CITY OF ALBUQUERQUE

November 7, 2011

**Re: Spectrum Assisted Living Drainage Report and Conceptual Grading and
Drainage Plan
Engineer's Stamp dated 10-28-11 (A12/D025)**

ENGINEER'S SEAL 	SPECTRUM ASSISTED LIVING	DRAWN BY DY
	RETAINING WALLS	DATE 11/14/11
	 TIERRA WEST, LLC 5571 MIDWAY PARK PLACE NE ALBUQUERQUE, NM 87109 (505) 858-3100 www.terrawestllc.com	2011026-C3C-R_WALLS
RONALD R. BOHANNAN P.E. #7868		SHEET # C3C JOB # 2011026

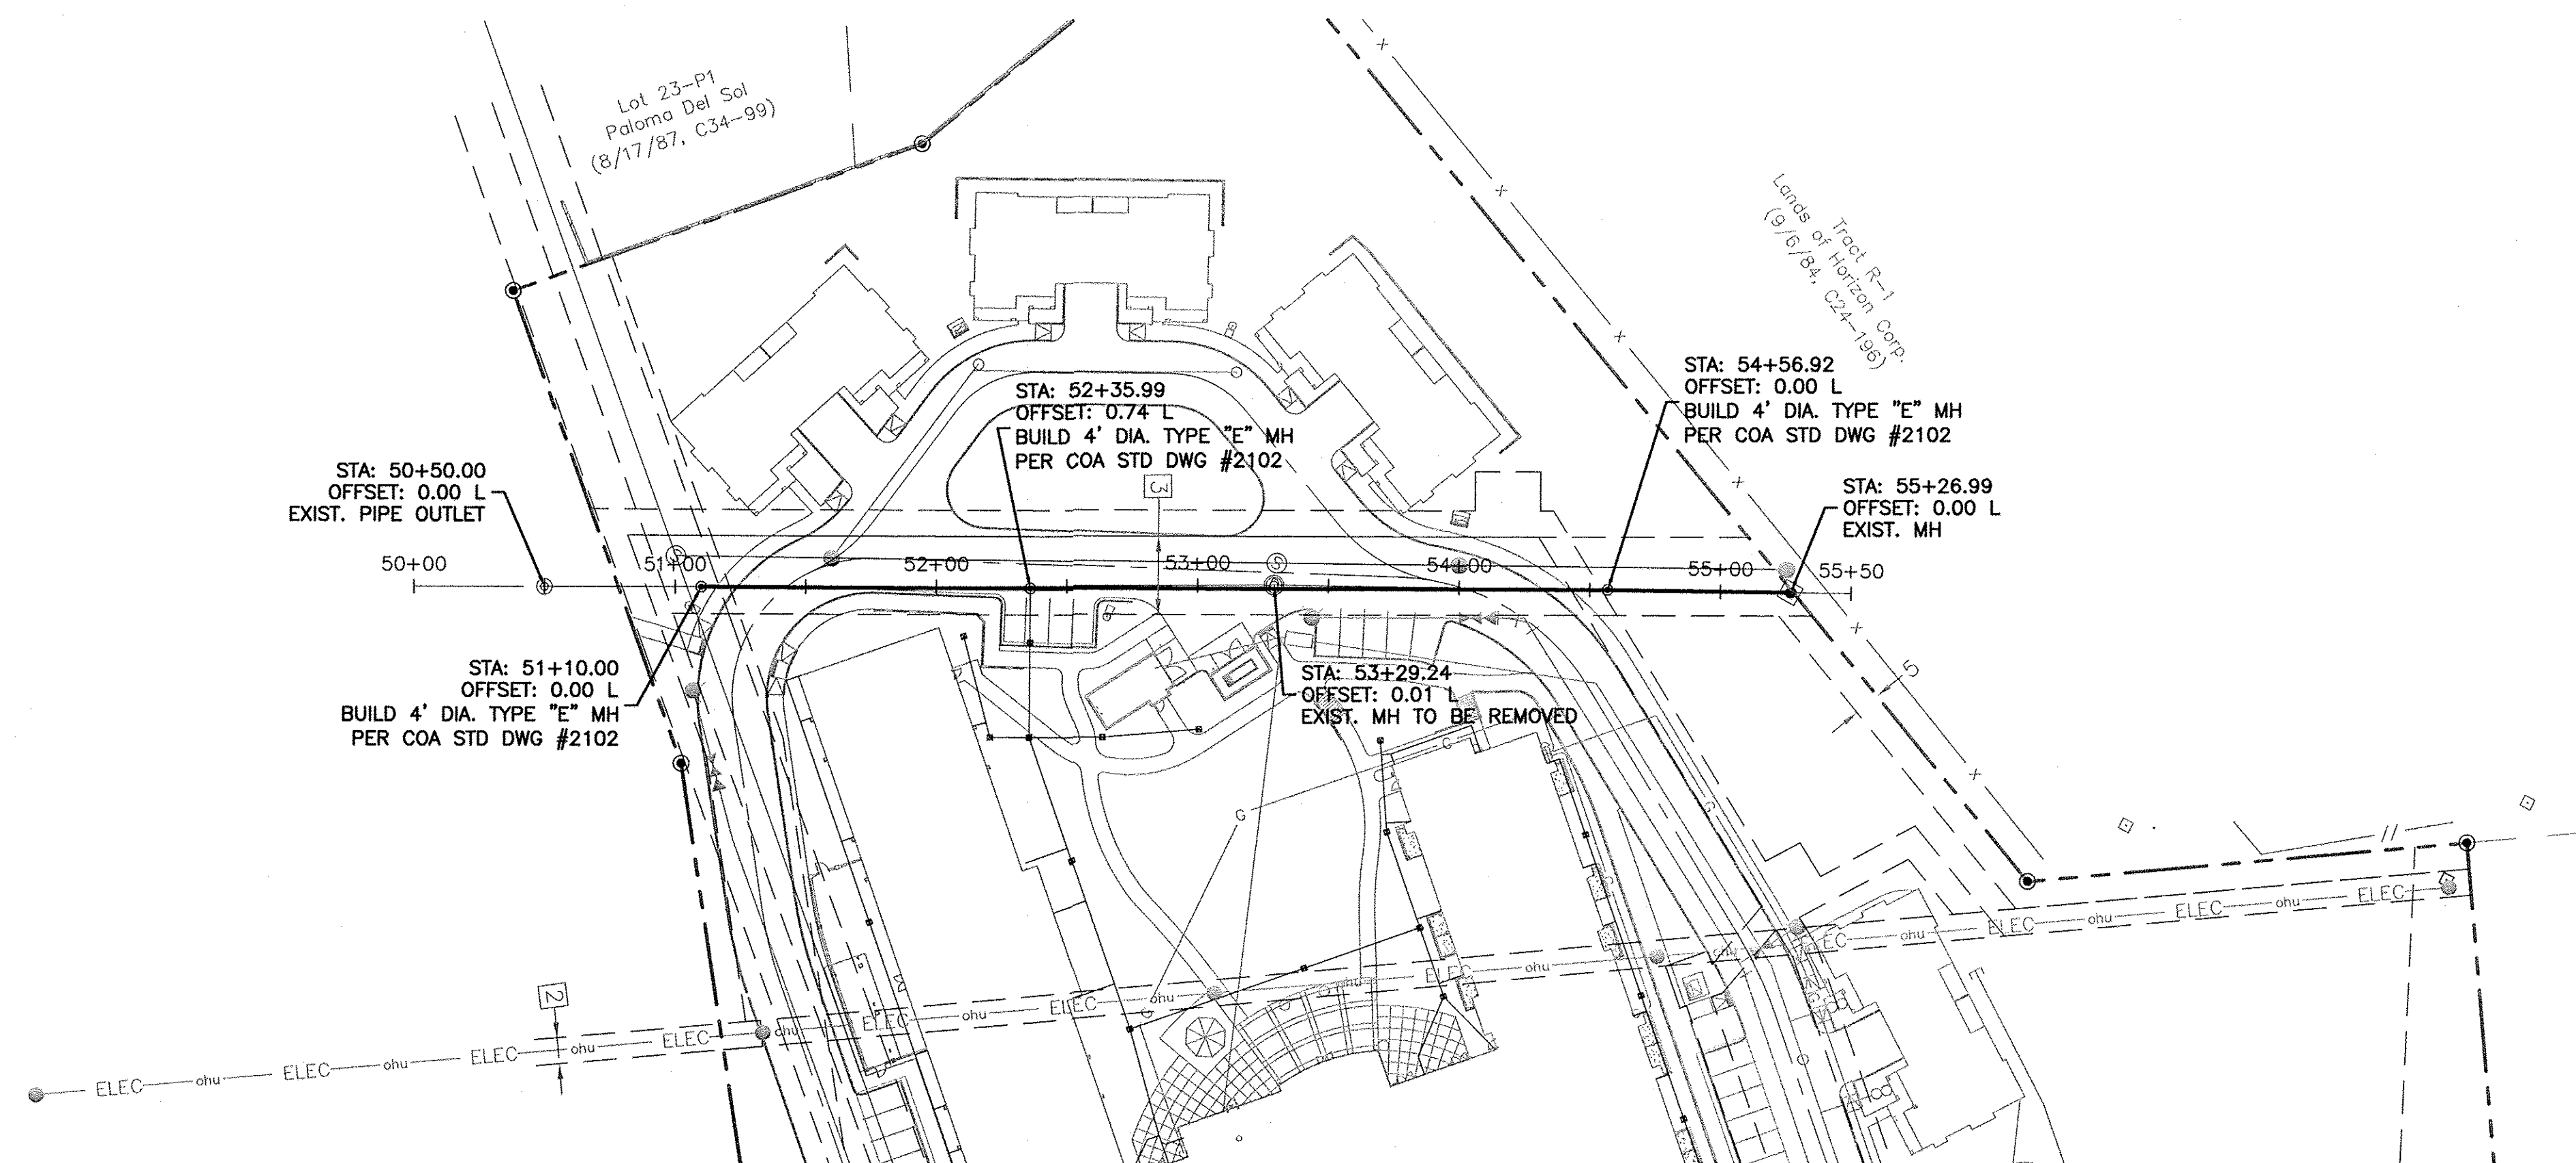
- Provide a Grading Plan for Lot 1 and 2.
- Provide TW/BW for proposed retaining walls.
- It would be beneficial to have an as-built profile for the storm drain from the apartment complex. Provide a sheet in the Grading Plan to accomplish this.
